Application no: **3/2020/0654**

Address: **51 Fell Brow Longridge Lancashire PR3 3RY**

Proposal: **Installation of new driveway to front including part of garden**

Block Plan shows area bounded by: 360471.97, 436980.41 360561.97, 437070.41 (at a scale of 1:500), OSGridRef: SD60513702. The representation of a road, track or path is no evidence of a right of way. The representation of features as lines is no evidence of a property boundary.

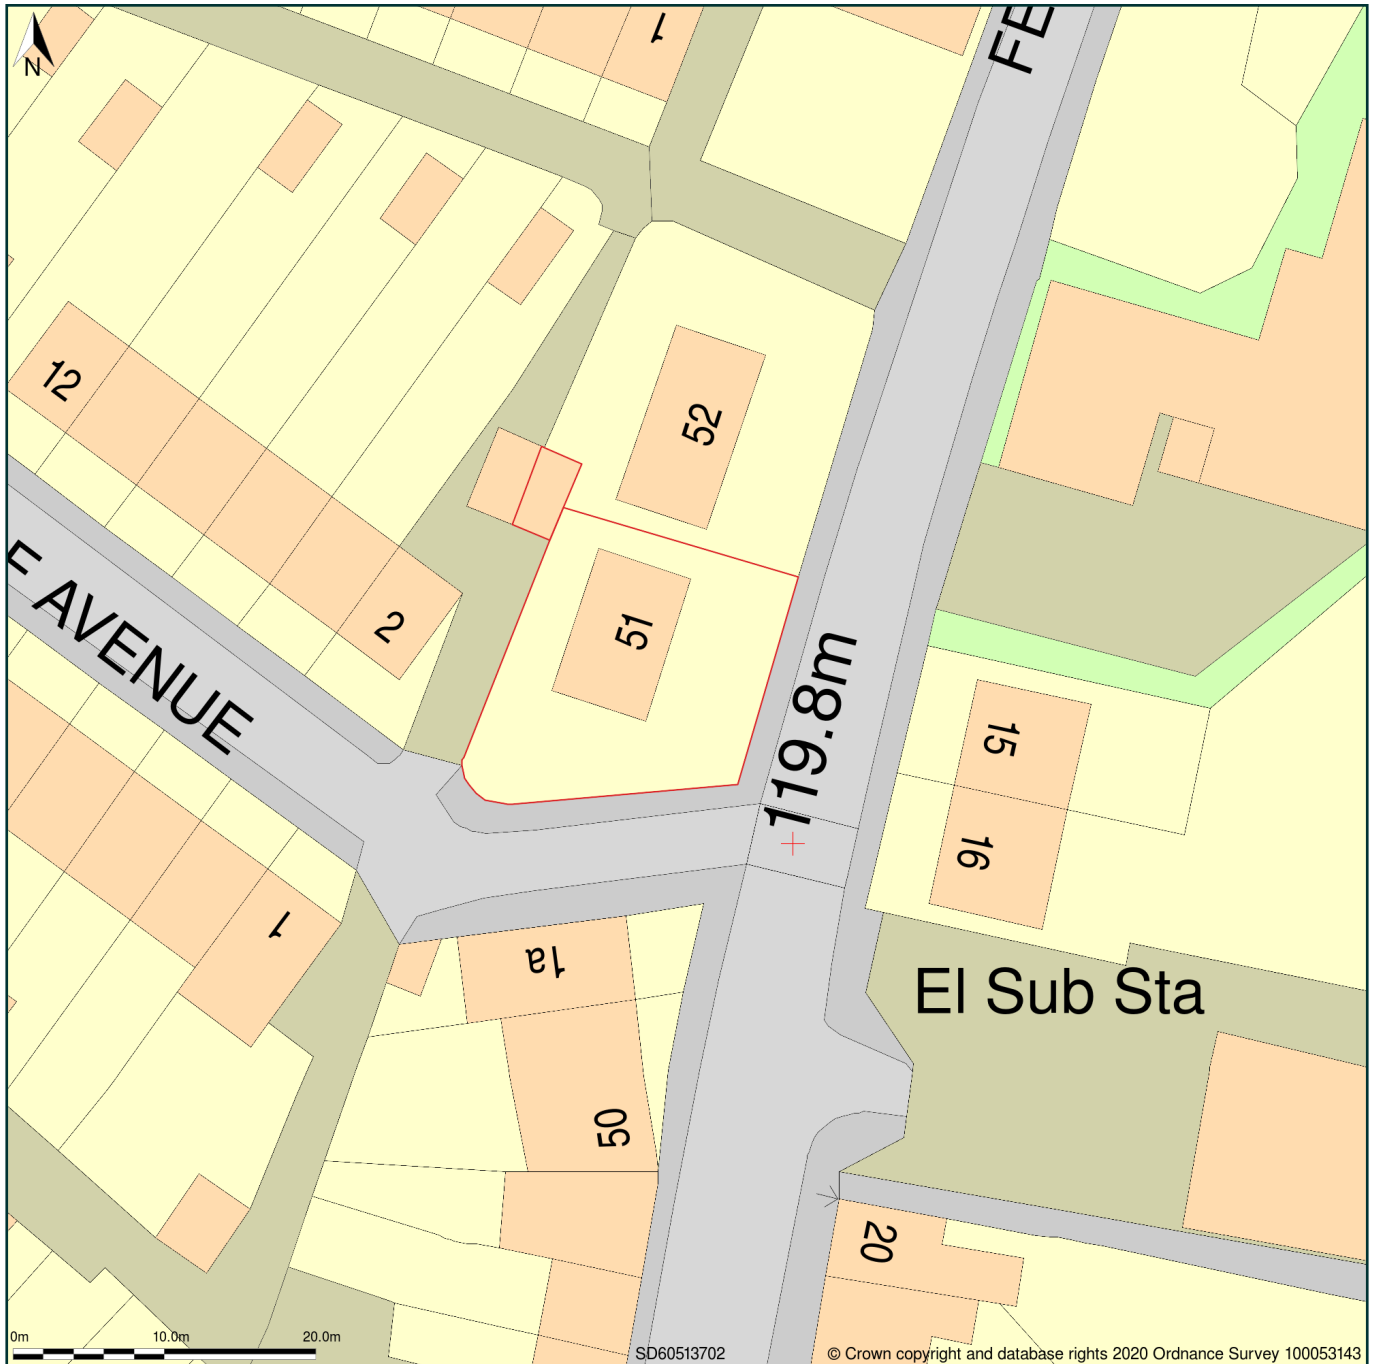
The proposed new driveway will provide two off-street parking spaces, and whilst the Local Highway Authority would support the proposal, I must ask that the visibility splays are protected at all times and remain clear and free from obstruction in perpetuity of the development proposal.

1. Notwithstanding the provisions of the Town and Country Planning (General Permitted Development) Order 1995 there shall not at any time in connection with the development hereby permitted be erected or planted or allowed to remain upon the land hereinafter defined any building, wall, fence, hedges, trees, shrubs or other devices over 1.05m above road level.
